Please ask for: Nicola Moore
Email: nicola.moore@arun.gov.uk
Telephone: Ext 37944
Our Ref: BR/231/20/PD
Your Ref:
Date: 30th September 2020

Prior Notification for Permitted Development (Non Householder)

Development: Notification for Prior Approval under Class O for change of use from office use (Class B1a) to residential (Class C3) - Conversion of existing office building into 15 No. self-contained residential units.

Location: Knighton Chambers 39 Aldwick Road Bognor Regis PO21 2LN

DRAWING.
Ground Floor as Proposed

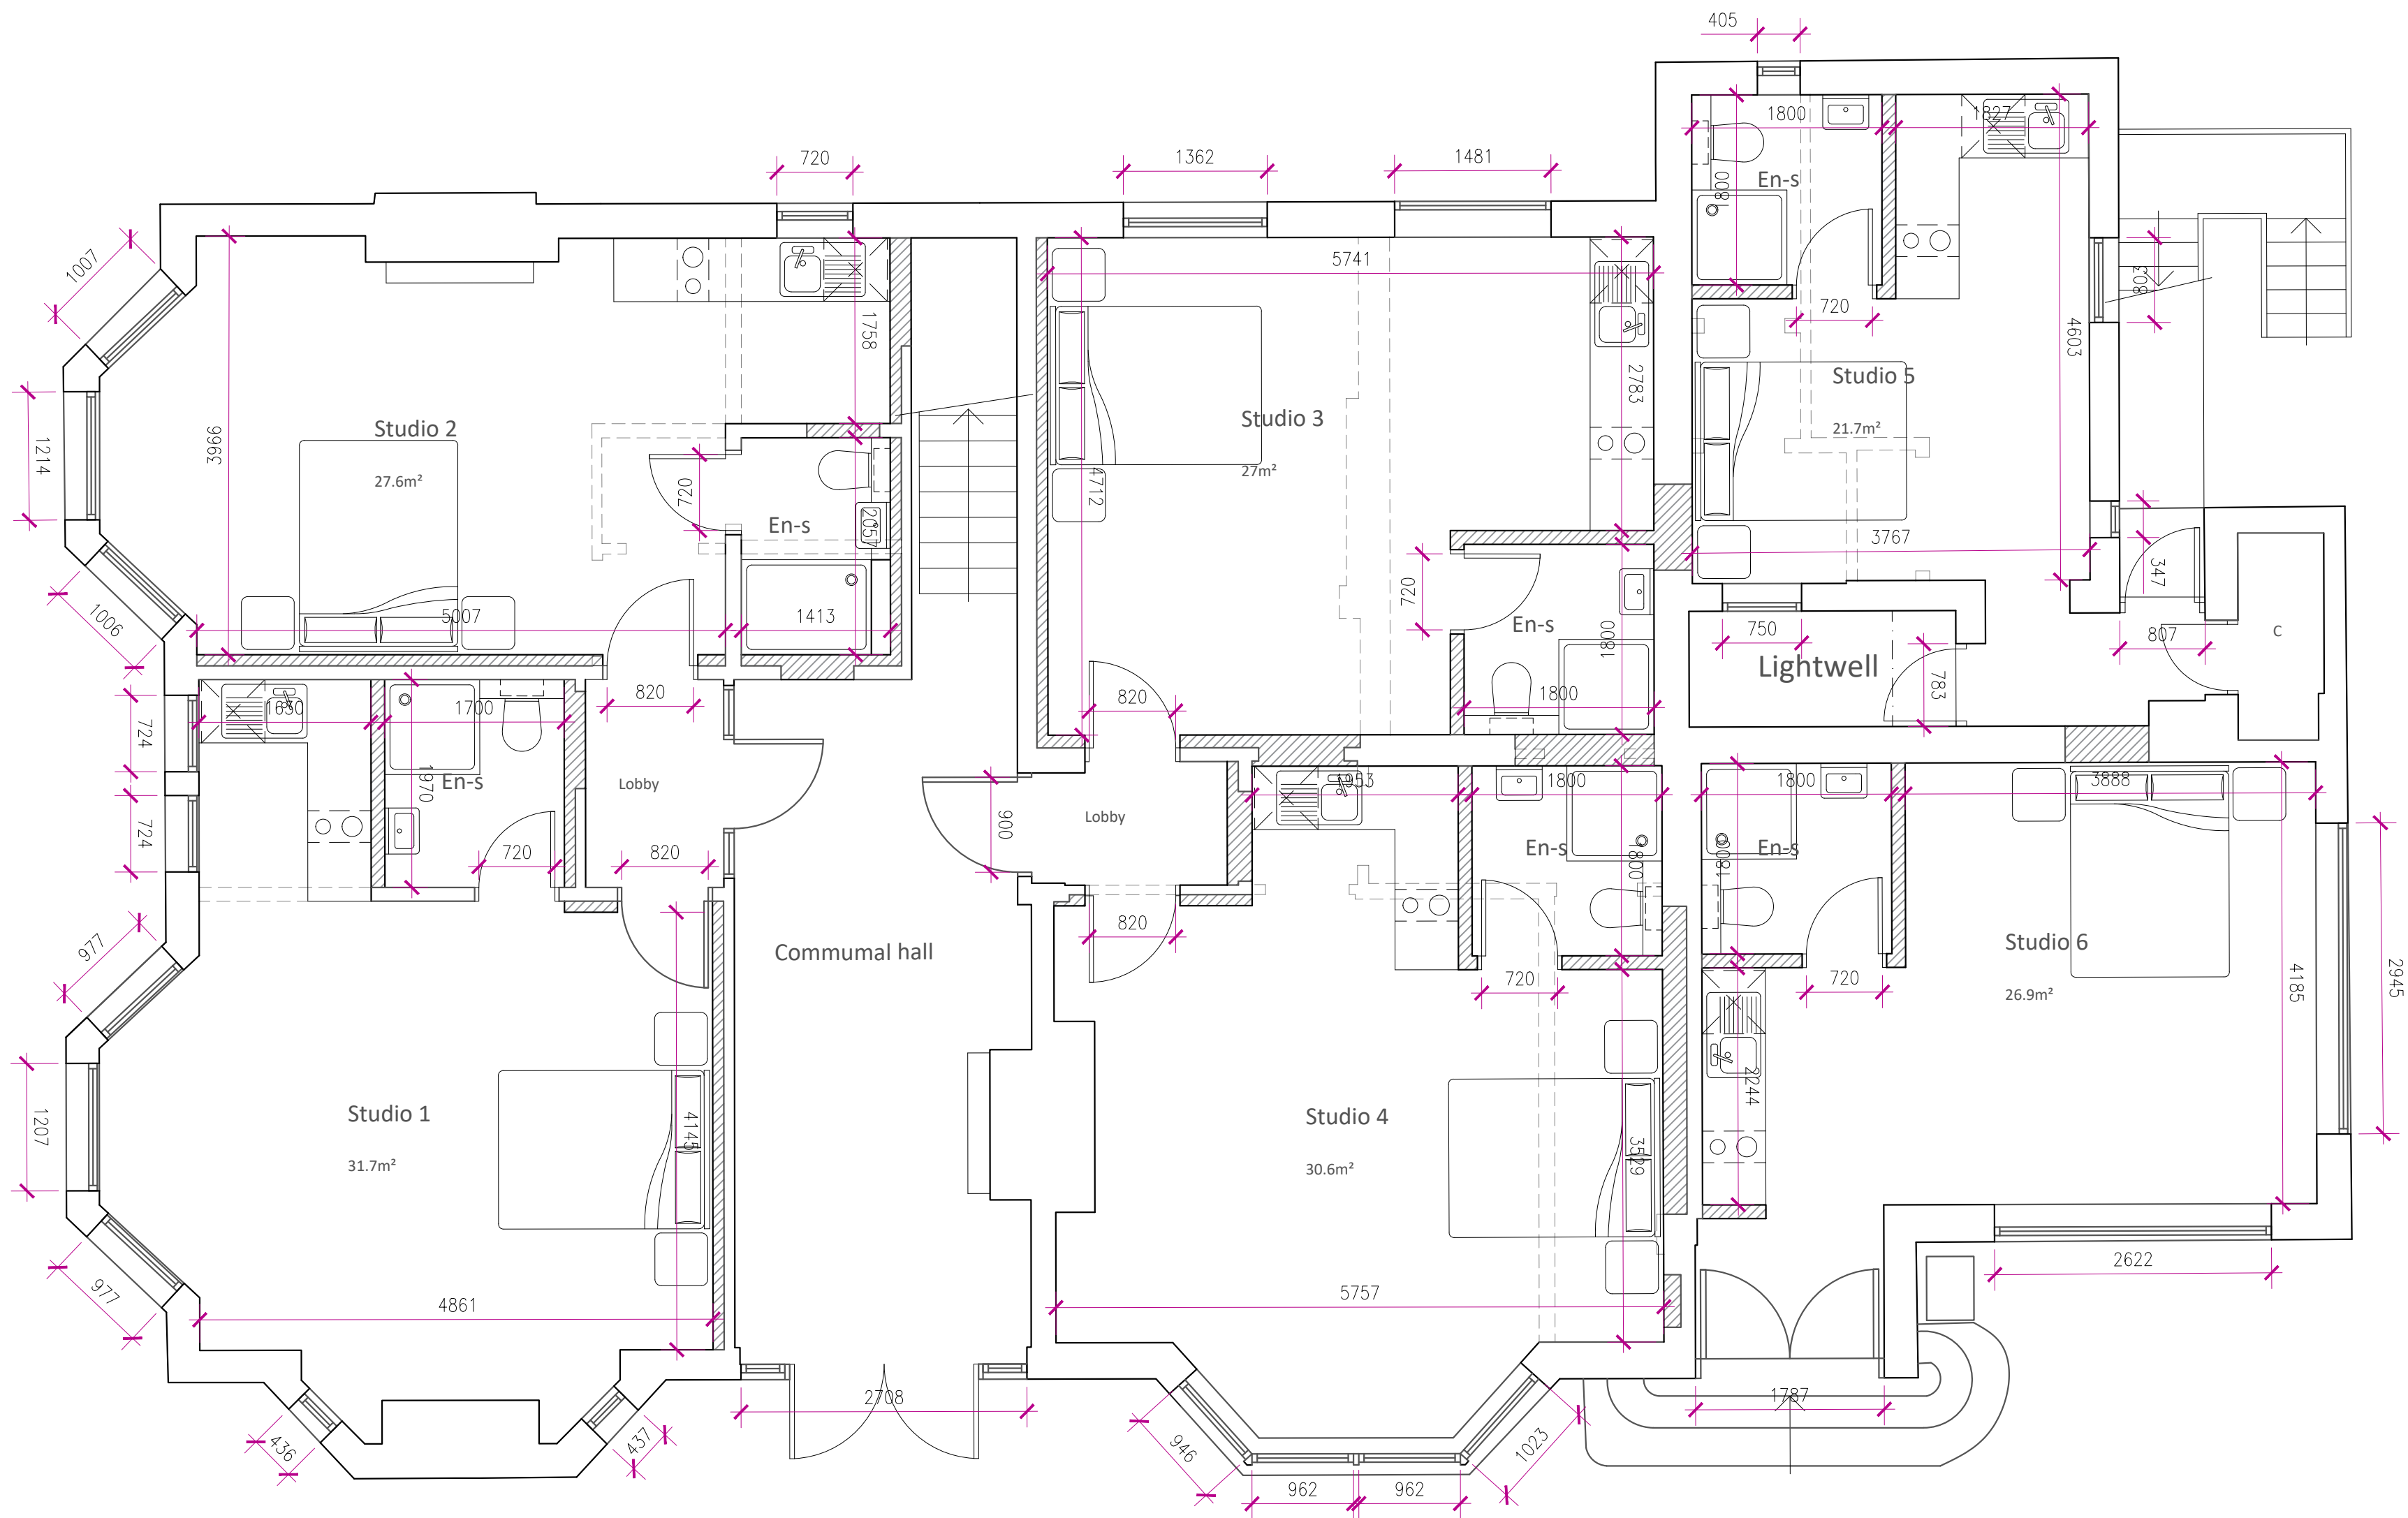
As per the General Permitted Development Order Part W (bc) in relation to development proposed under Class M,N,O,PA or Q, a floor plan is indicating the dimensions & proposed use of each room, the position & dimensions of windows, doors & walls is required. Please amend the submitted floor plans accordingly to include dimensions and re submit.
